M54 to M6 Link Road

8.8 LIU(I) Draft Statement of Common Ground with Ian Simkin & Adrian Simkin

M54 to M6 Link Road
Development Consent Order 202[]

STATEMENT OF COMMON GROUND

Drawing Title
**FIGURE 12.2:
 WALKING, CYCLING
 AND HORSE RIDING FACILITIES**

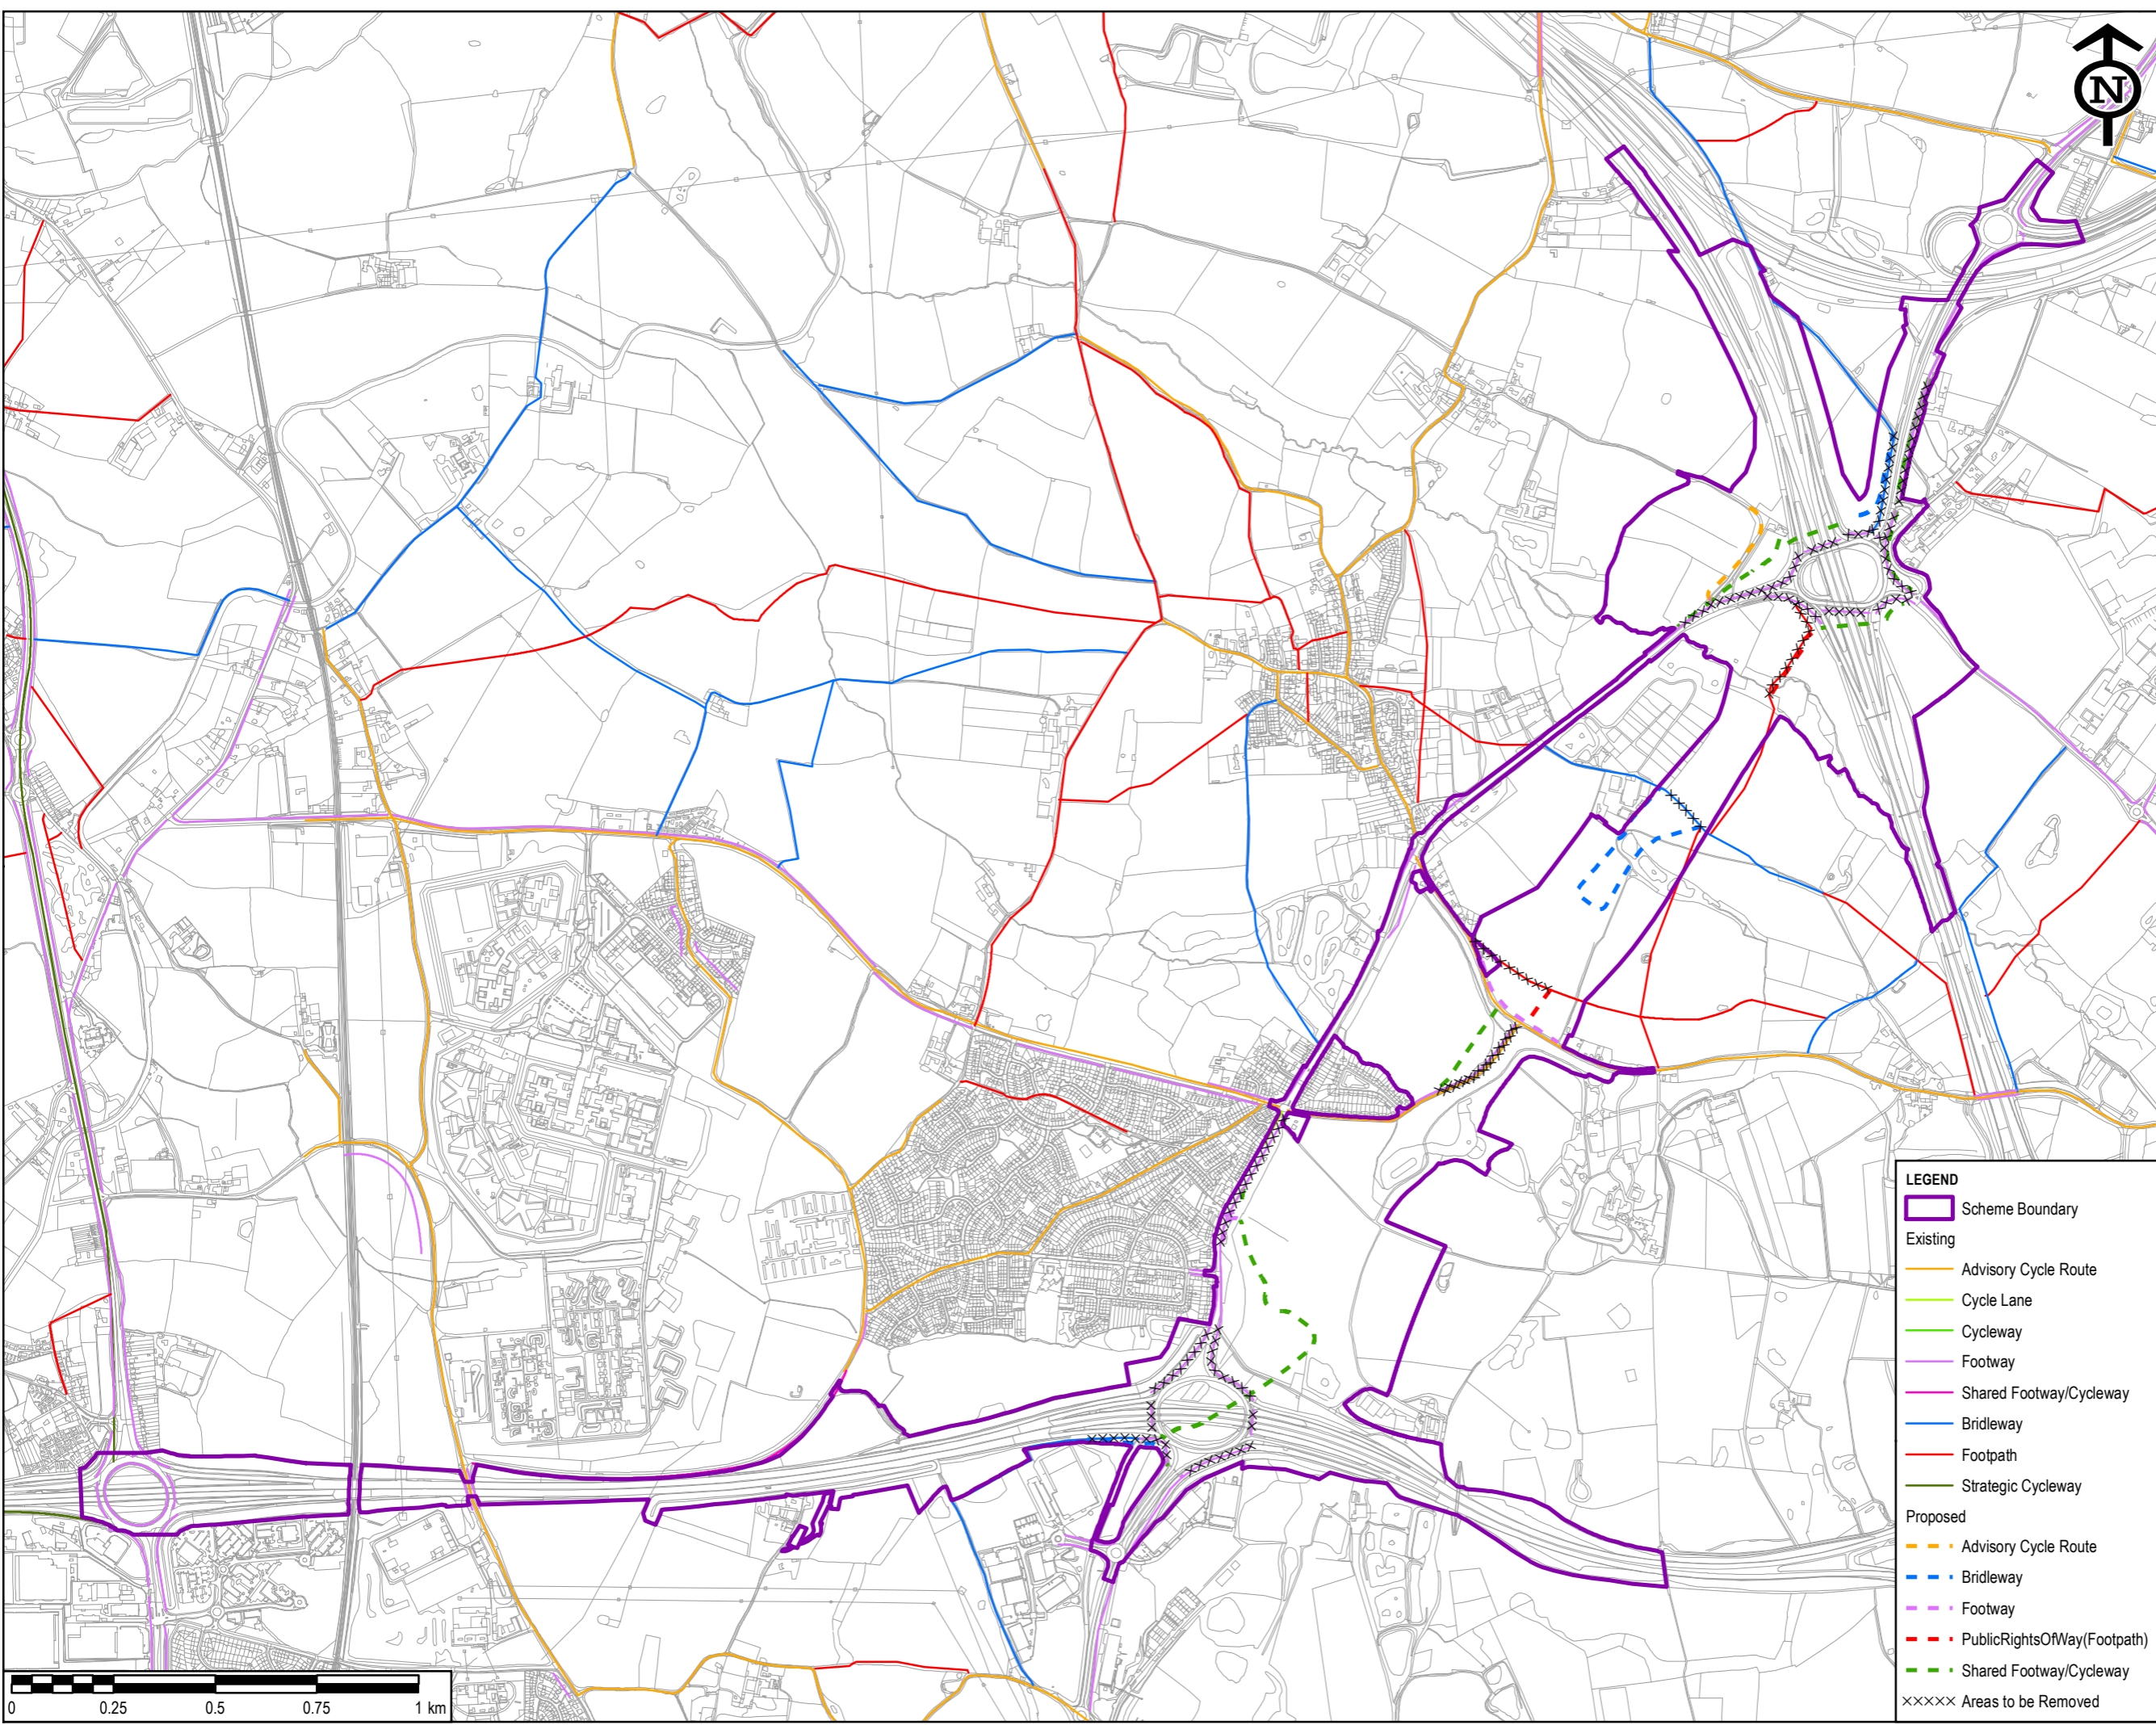
considered dangerous and therefore, we feel unnecessary to be reinstated within the road scheme, especially as the increased road noise and proximity to traffic will not be expected to increase its use. As part of the Environmental Statement (ES), the 2017 walking, cycling and horse riding (WCH) survey results showed no recorded users of this particular public right of way for the duration of the data collection period (Environmental Statement Chapter 12 [TR010054/APP/6.1]). The Environmental Statement Chapter 2 [TR010054/APP/6.1] sets out that the Environmental Masterplan includes measures to 'ensure	upgraded, where required, to an acceptable standard to address any safety concerns.			
--	--	--	---	--	--	--

the connectivity of PRoW and other routes used by pedestrians and cyclists are maintained', this is in opposition with the survey results. The route, Saredon BW13 is not used, as evidenced in Chapter 12 of the ES and therefore should be removed, as opposed to realigned, as part of The Scheme. No evidence has been provided by HE to justify the acquisition of these rights.				
--	--	---	--	--	--	--

FIGURE 2.6
DRAFT ENVIRONMENTAL
MASTERPLAN
SHEET 4 OF 5

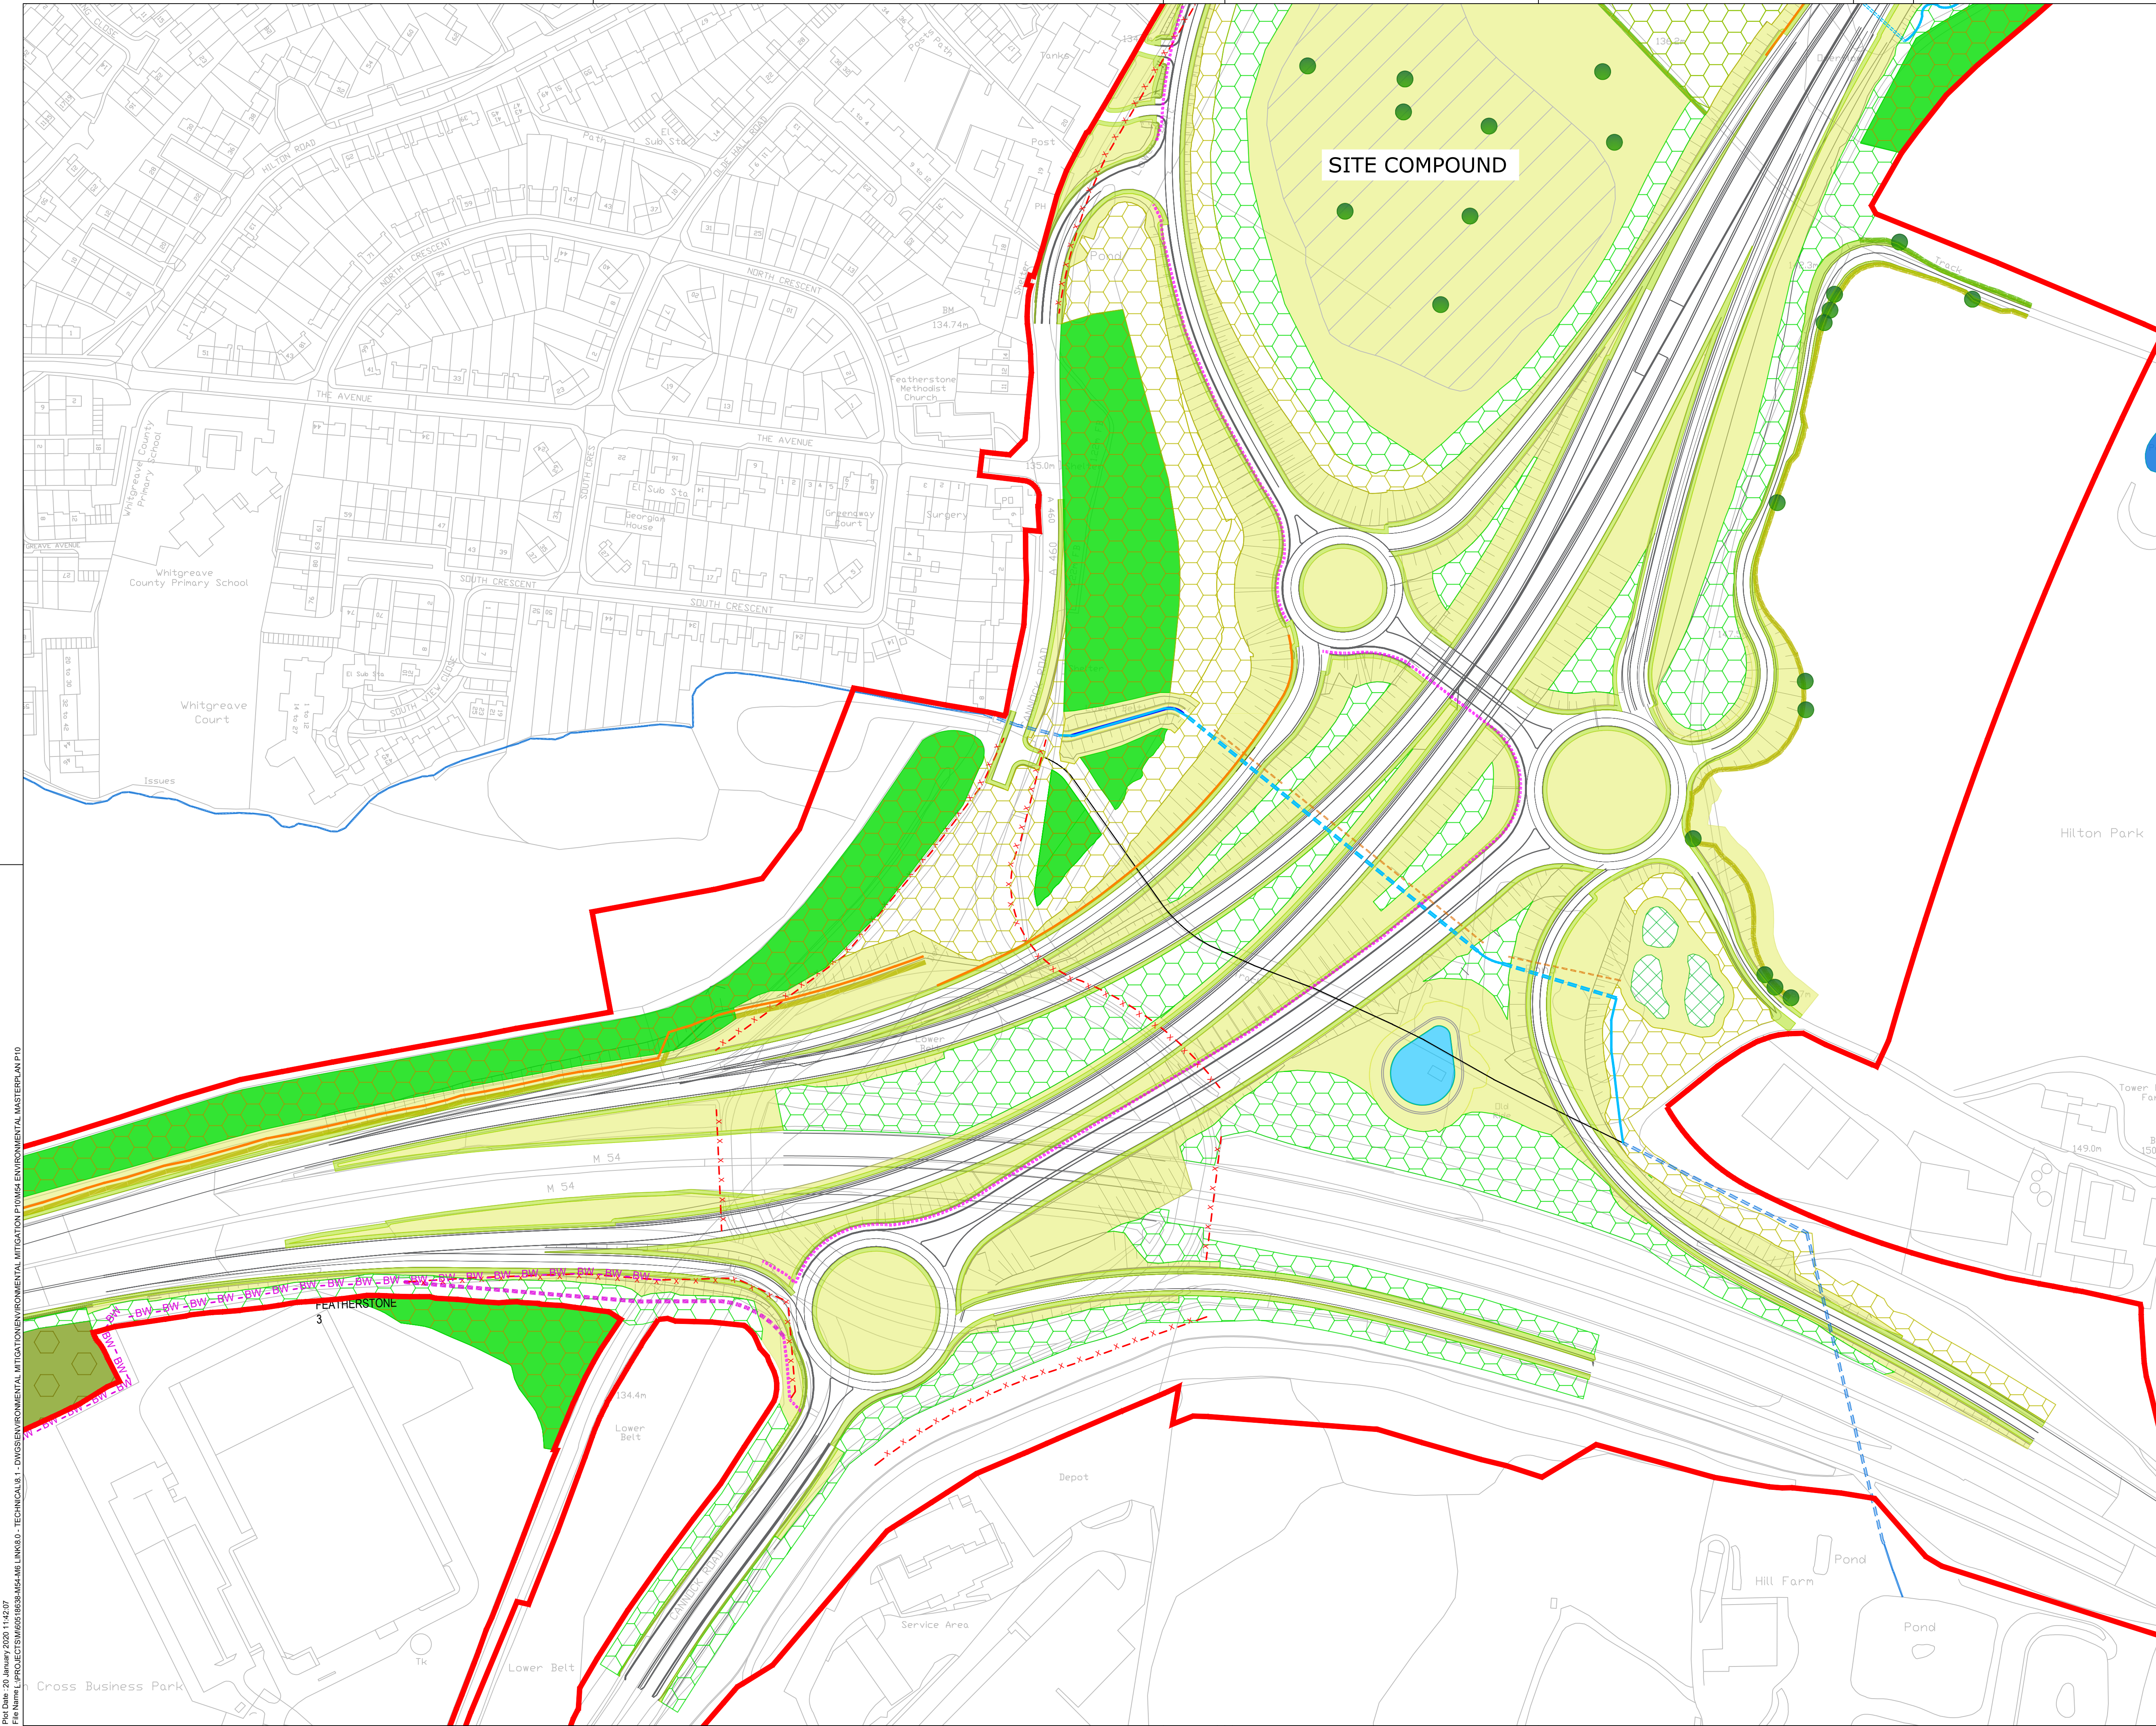
Bridleway realignment	Letter from Bagshaws, 28/01/20	Plot 6/31 is shown as a narrow blue line on the road scheme plan and detailed in your interest schedule to be required temporarily and rights to be acquired permanently. We can only assume this relates to the proposed position of a public bridleway, however, it	Plot 6/31 is in the correct position. The blue shaded area indicated the rights area required for the realignment of the bridleway. This is indicated as a corridor to include the horizontal limits of deviation for the adjacent highway which accounts for the slight variation in marked location. The proposed location is as per the Draft Environmental Masterplan (as	Under discussion	Medium

does not appear to sit in the correct position on the Draft Environmental Masterplan dated 8th November 2019, revision PO9. When scaled off the bridleway was in an entirely different position to that shown on the road scheme plan.'	presented at November 2019 supplementary consultation) which currently sits within Plot 6/23 however as the route runs alongside the bottom of the embankment it is necessary to provide a corridor to account for the horizontal limits of deviation therefore the blue area shown is the edge of the corridor.			
	Land agent's response to the consultation on changes to the DCO, also raised in land agent's Relevant Representation RR-033 and letter received from Bagshaws dated 28/01/2020	(With regards to Change 7) We note the previously objected to acquisition of plot 6/31, for the provision of a bridleway, Saredon BW13, which terminates at M6 Junction 11, still remains as part of the scheme on both the revised land plans and Environmental Masterplan overview revision plan. The Bridleway is not used, and has been unused for many years, it is	The bridleway is a PRoW and the Applicant is required by policy and legislation to retain connectivity of PRoW where possible. Lack of use is not sufficient justification by itself to extinguish a PRoW. The Scheme seeks to maintain existing levels of non-motorised user connectivity as a minimum requirement. The route currently connects into M6 Junction 11 where crossing facilities are provided to enable connectivity over the M6. The Scheme proposes to improve the crossing facilities for non-motorised users at M6 Junction 11. This route provides a connection between M6 Junction 11 and Great Saredon therefore it is anticipated that this route will be required to be re-instated and	Under discussion	Medium
